From: David Easton
Sent: 20 December 2017 09:19
To: Karen Parsons
Subject: FW: A/155/17/OUT - Avenals Barn, Angmering
Attachments: Proposed dwellings - Plan Elevations.pdf; Proposed dwellings - Site plans.pdf

Subject: A/155/17/OUT - Avenais Barn, Angmering

- Amendment A**
1. Gardens increased to 10m
 2. Right of way included to Weavers Hill
 3. Patio door removed from front elevation, replaced with 2No. windows

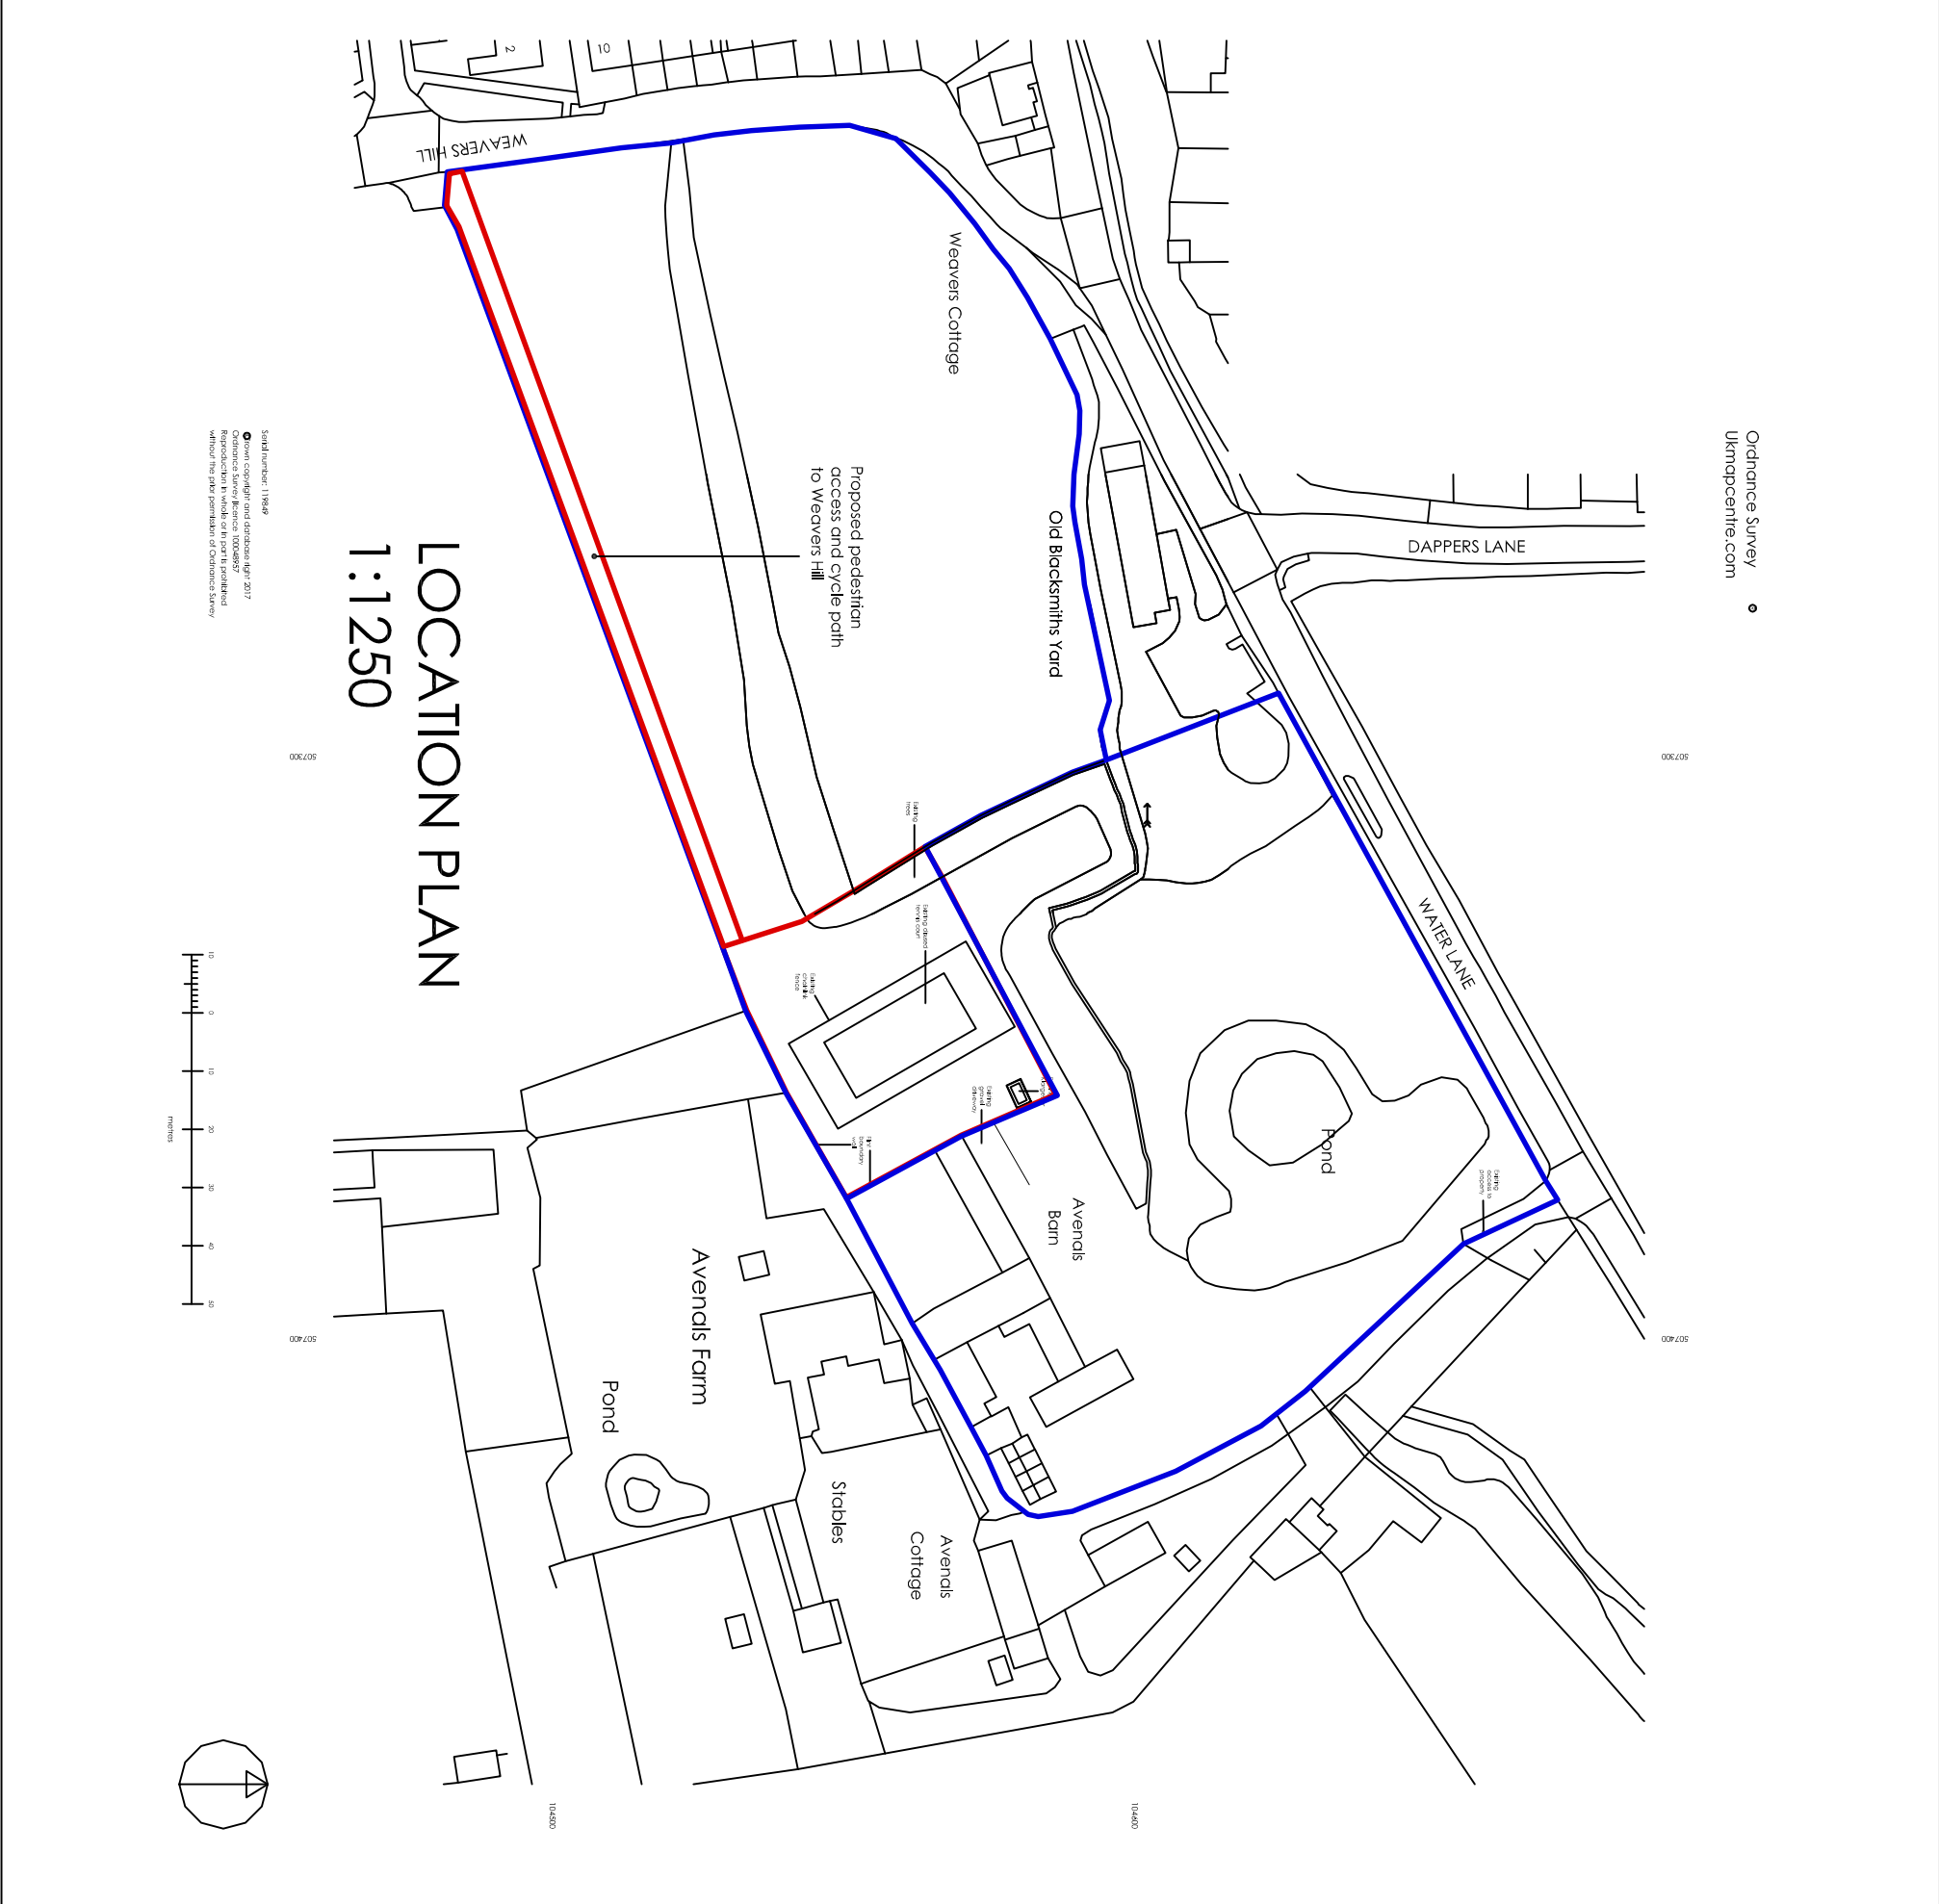
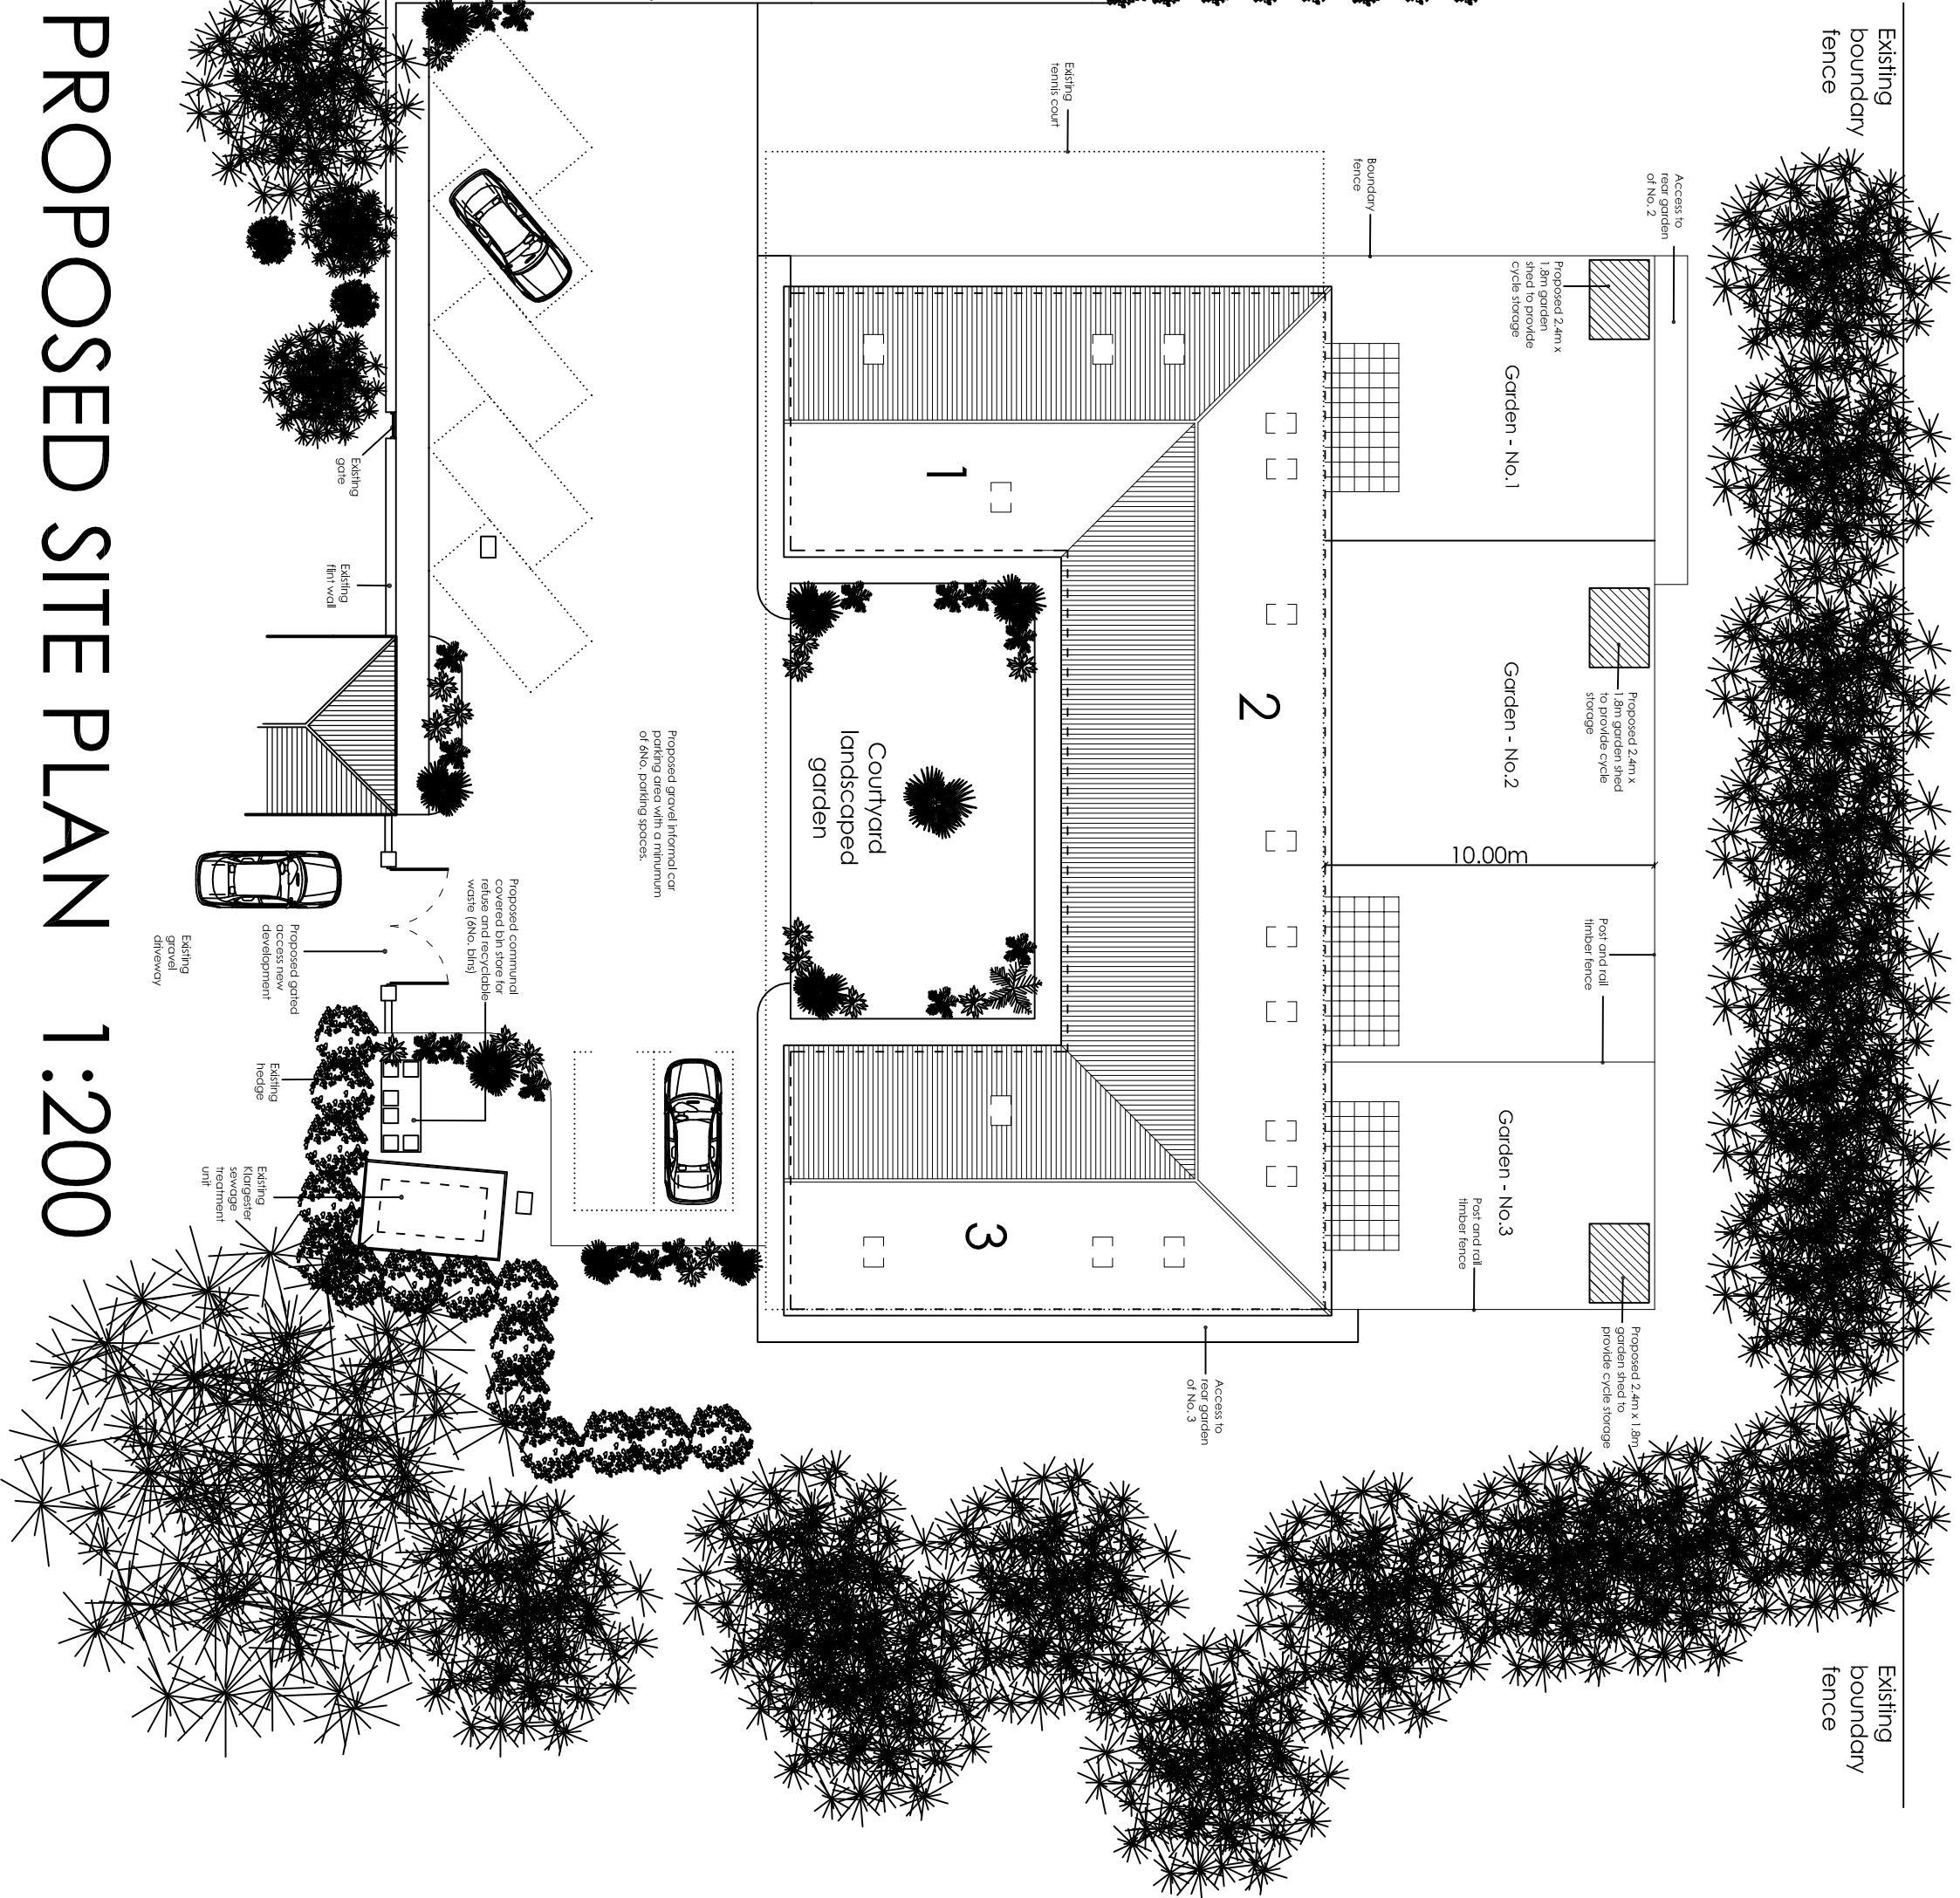
As discussed the major concern held by the Council at this time relates to the severance of the site due to the absence of a pedestrian footway along Water Lane. Therefore, despite the distances being considered acceptable the absence of this pedestrian link prevents the site from being considered sustainable. However, following our discussions you have advised that the applicant in this case owns the land to the west of the application site and as such the red edge could be extended to Weaver's Hill to provide a pedestrian link into Angmering. Therefore, I would advise that an location plan is submitted to allow the LPA to secure this pedestrian link.

I have also advised that some concerns exist in relation to the garden sizes of Plot 1 and 3 and as such recommend that some consideration is given to how best to meet the requirements of policy D DM3 of the emerging Local Plan.
